From: Martyn White <Martyn.White@arun.gov.uk>
Sent: 31 January 2020 13:50
To: Maria Tomalova <Maria.Tomalova@arun.gov.uk>
Subject: BN/96/19/L

BN/96/19/L

The consent seeks approval for the removal of a collapsed West Greenhouse along with the planned removal of an unsafe South Greenhouse. These structures will be replaced with Orangeries in the style of Anglo Dutch design/17th century vernacular.

Title South Orangery

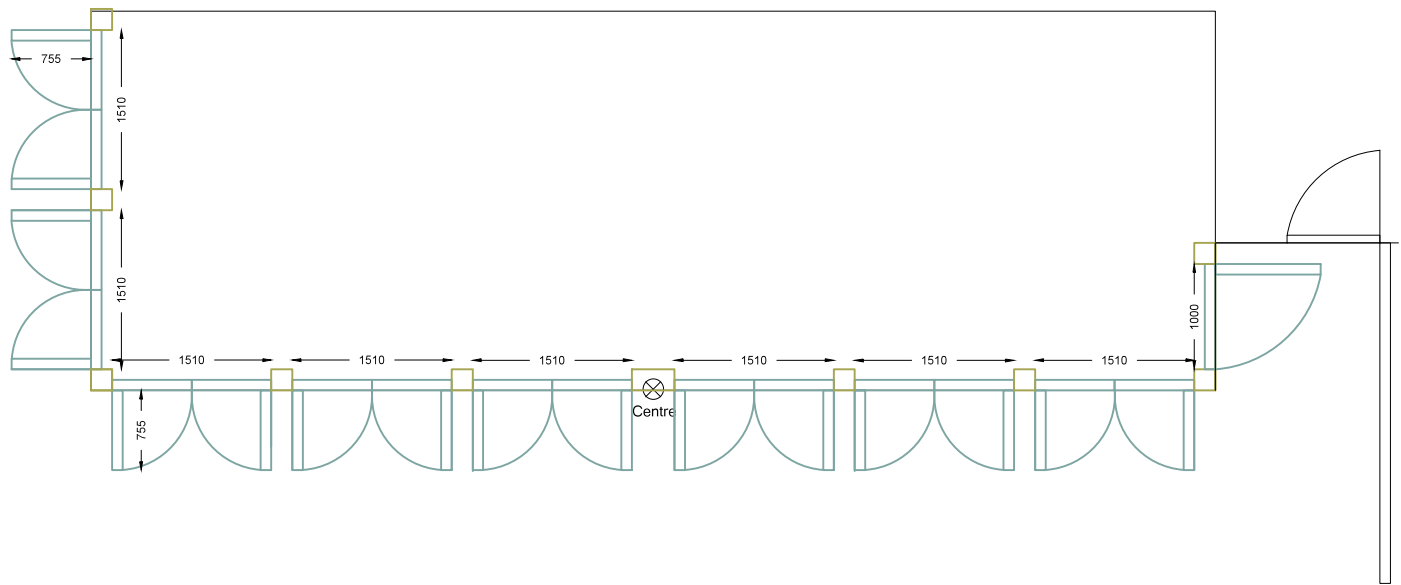
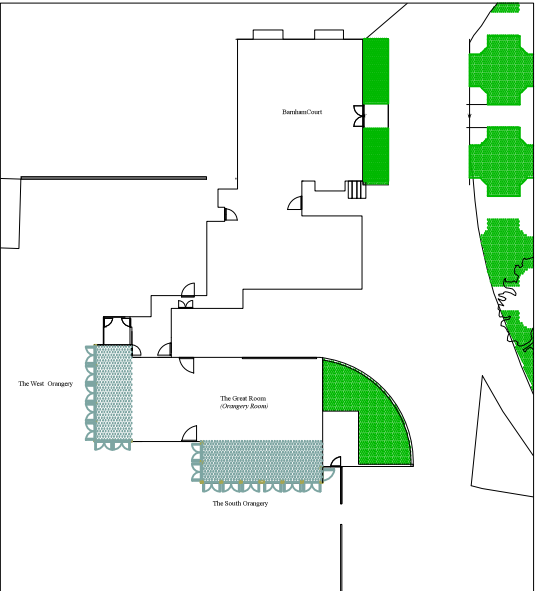
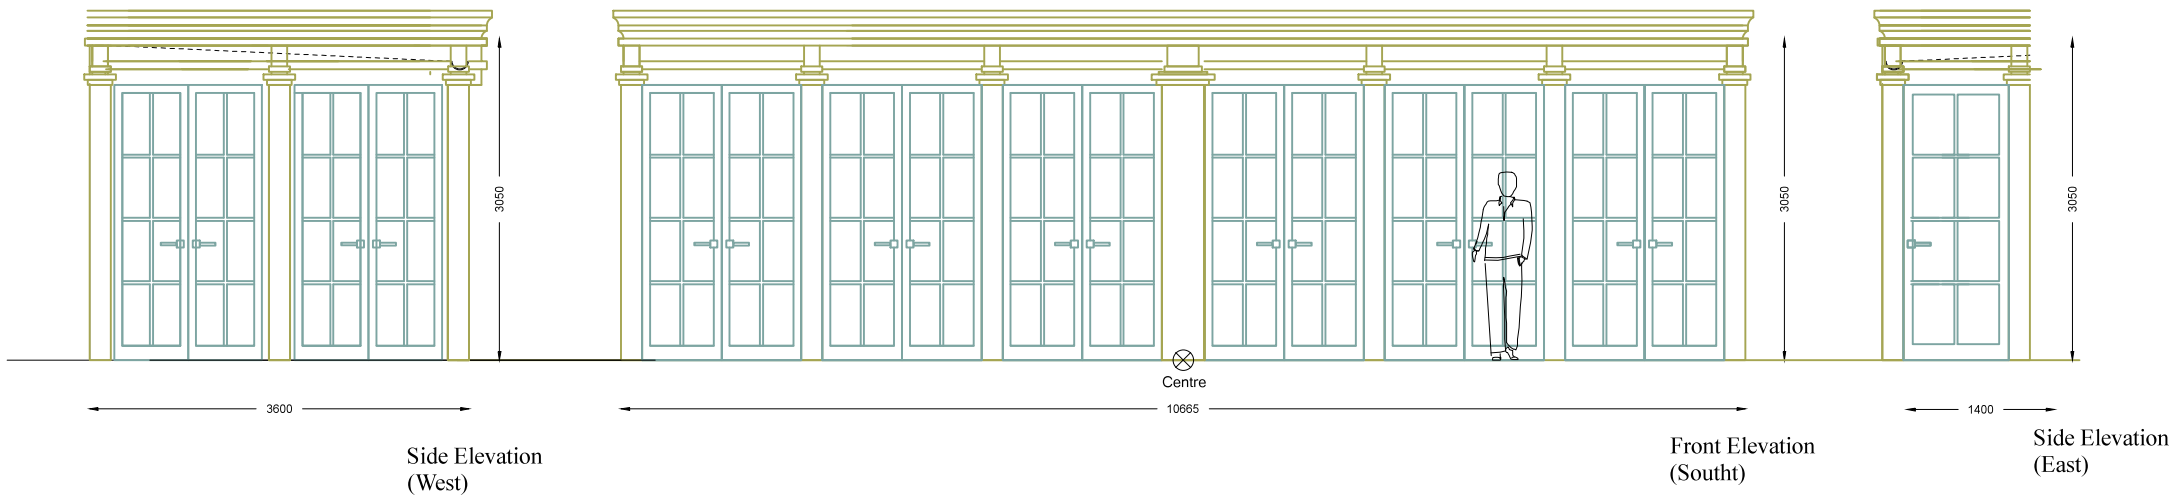
Detailed drawings of all the joinery including the doors and oak timber posts with Doric columns should also be provided along with details of the proposed colour. Whilst this might be the same as existing elsewhere, it would

help to have the actual colour name/reference no. on file. Drawings should be provided at an appropriate scale and provide details of the glazing/glazing bars.

| Title                                                                                                                         | West Orangery Proposed |

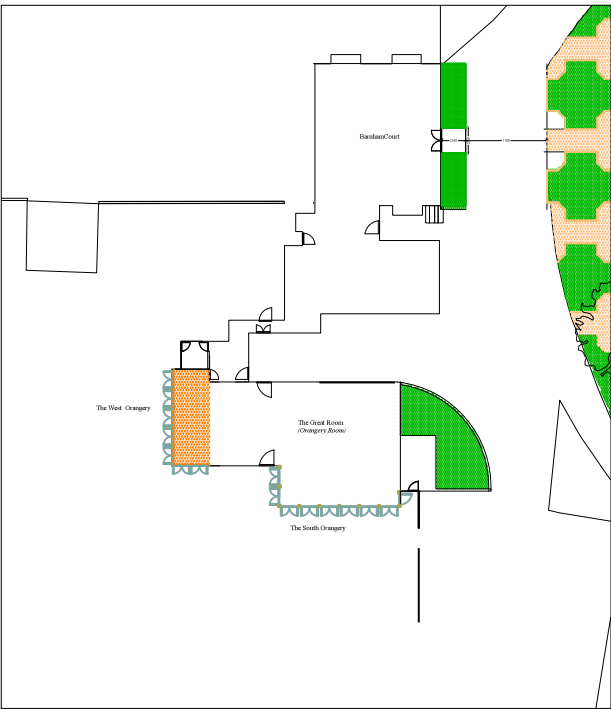
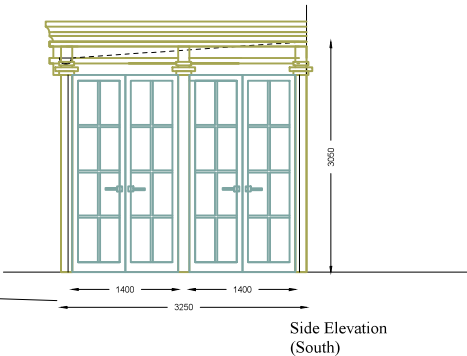
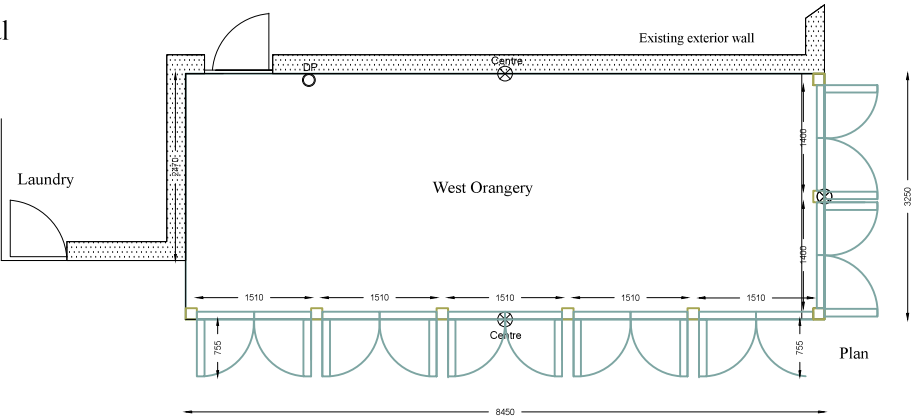
It is not clear how the western orangery will join up to the existing single storey laundry structure, especially with regards to the existing roof structure and associated rainwater goods. Details of this junction should be provided to the council at an appropriate scale.

It is also noted that the proposed plans indicate a new door opening from the existing garage/service building into the western orangery. However, it is not clear if this opening currently existing or not. Therefore, if it is a new opening, details of any new door/opening should be provided to the LPA by way of condition.
